RE: Gardiane Short Plat (SP-08-08)

The Kittitas County Community Development Services Department has determined that the Gardiane Short Plat (SP-08-08) is a complete application and hereby grants **conditional preliminary approval** subject to the following conditions:

TO: Trudie Pettit, Community Development Services
FROM: Christina Wollman, Planner *ICW*
DATE: June 18, 2008
SUBJECT: Gardiane Short Plat SP-08-08

GARDIANE SHORT PLAT SP 08-NE4, S4, T19N, R16E, WM

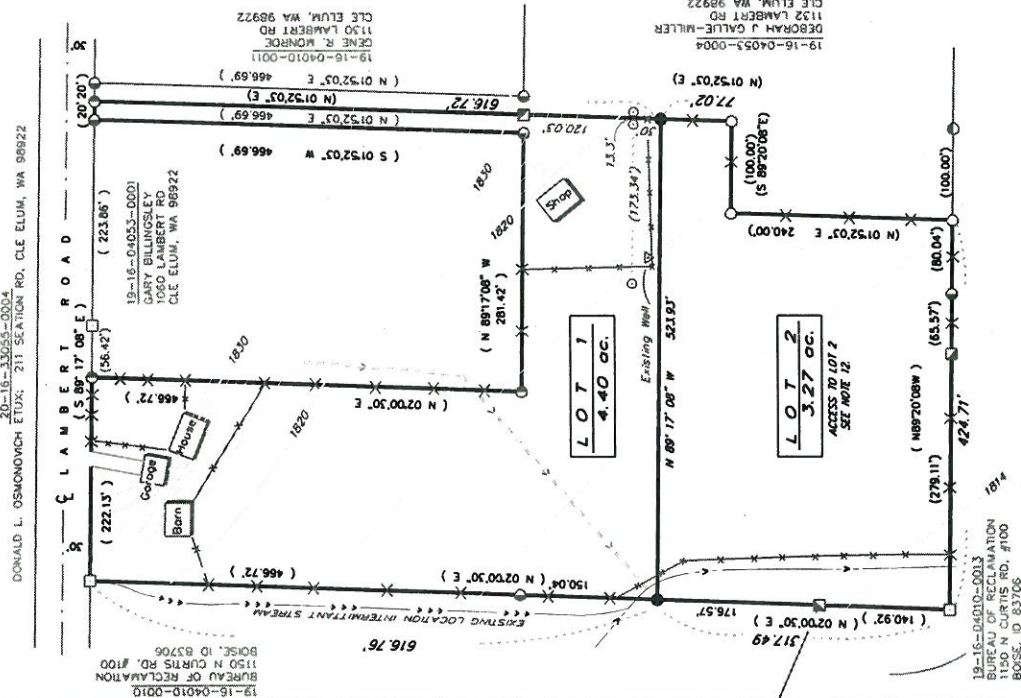
3. The 100 year floodplain boundary of the Teanaway River shall be clearly delineated on the final mylars.
4. The PSSC and PEMC wetlands located on lot 1 and lot 2 shall be clearly delineated on the final mylars.

1. Legal Description: The legal description appears to be missing the reference to the second page number in Book 21. The page number is 82.
2. Lot 2 Access: Per Kittitas County Road Standards, accesses that serve three or more lots must be constructed as a private road. The proposed access to Lot 2 will serve three or more lots and must be constructed to meet the requirements shown below, including a cul-de-sac at the end of the road. A 40' easement is required for the roadway and a 110' diameter easement for the cul-de-sac.

4. Private Road Improvements: Access from Lambert Road to the turnaround shall be constructed to meet or exceed the requirements of a High-Density Private Road that serves 3-14 tax parcels. See Kittitas County Road Standards, 9/6/05 edition.

5. Cul-de-Sac: A cul-de-sac turn-around having an outside right-of-way easement diameter of at least 110 feet shall be constructed at the closed end of all dead-end roads serving 3 or more lots. The driving surface shall be at least 96 feet in diameter. Cul-de-sacs must also conform to the requirements specified by the 2006 International Fire Code. Contact the Fire Marshal regarding any additional cul-de-sac requirements.

6. Plat Notes: Note 9 shall be removed from the final plat. Notes 6 and 7 shall be updated to reflect verbatim the following:
- a. Maintenance of the access is the responsibility of the property owners who benefit from its use.
